PROPOSED NORTH FALLS OFFSHORE WIND FARM DEVELOPMENT CONSENT ORDER

PINS REFERENCE EN010119

LONDON GATEWAY PORT LIMITED (IP REF 20050576)

RESPONSE TO THE EXAMINING AUTHORITY'S SECOND WRITTEN QUESTIONS (ExQ2)

Deep Water Route Cable Installation Areas (Future Dredging Depths) Plan

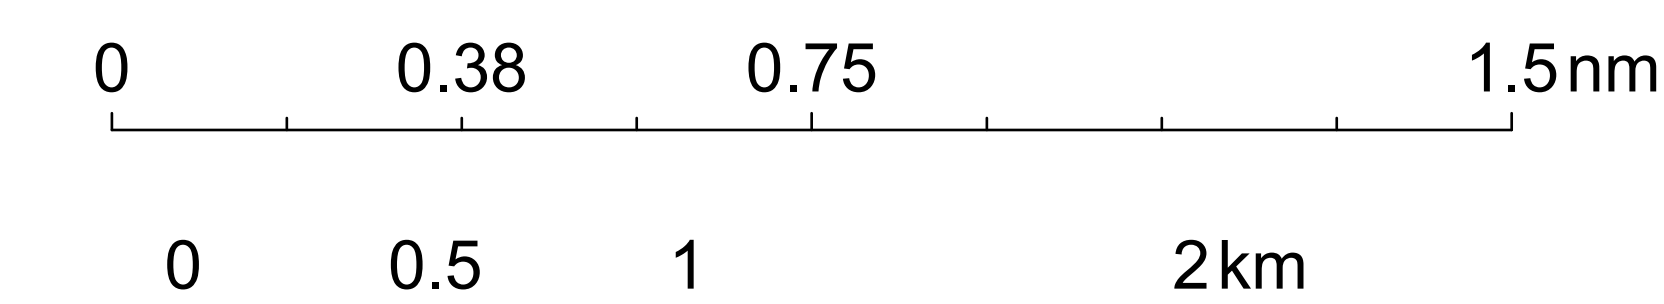
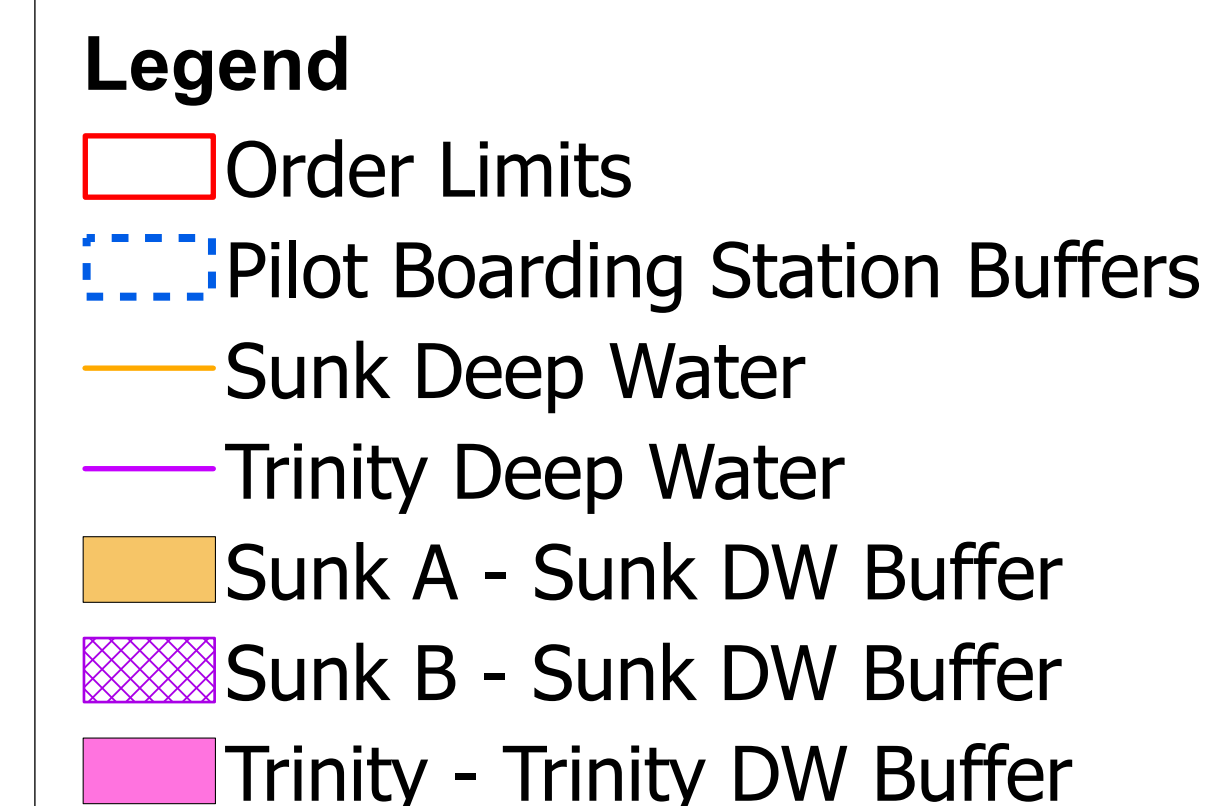
No:	Question to	Question	Response
Q9.1.1	The applicant, London Gateway Port Limited (LGPL), PLA	<p>Requirement 2 (3) – Offshore design parameters</p> <p>The applicant's post hearing summary [REP4-034] confirms that the applicant has considered the ports' request for a dDCO requirement to ensure the seabed can be dredged to a depth of 22m Chart Datum further and the applicant has proposed drafting for a new requirement 2(3) in Schedule 1, Part 3 of the dDCO [REP4-004] to secure the cable burial depths in the Deep Water Routes. The applicant and the ports are requested to confirm that the drafting of this requirement is agreed, and the matter resolved. If not, please identify any amendments sought giving reasons.</p>	<p>LGPL welcomes the inclusion of the proposed Requirement. LGPL has already conveyed to the Applicant that it considers the following drafting clarifications to be necessary:</p> <p>"(3) Any part of Work No. 3 and any associated development <u>the authorised development</u> located within the following areas shown on the Deep Water Route Cable Installation Area (Future Dredging Depths) Plan, must be <u>designed</u>, installed, <u>operated</u> and maintained at a level which would not preclude dredging:</p> <ul style="list-style-type: none"> (a) of the area shown shaded in orange and labelled Sunk A – Sunk DW Buffer, to a level of 22 metres below Chart Datum; (b) of the area shown shaded in pink and labelled Trinity – Trinity DW Buffer, to a level of 22 metres below Chart Datum; and (c) to the area shown cross hatched purple and labelled Sunk B – Sunk DW Buffer, to a level of 19 metres below Chart Datum.
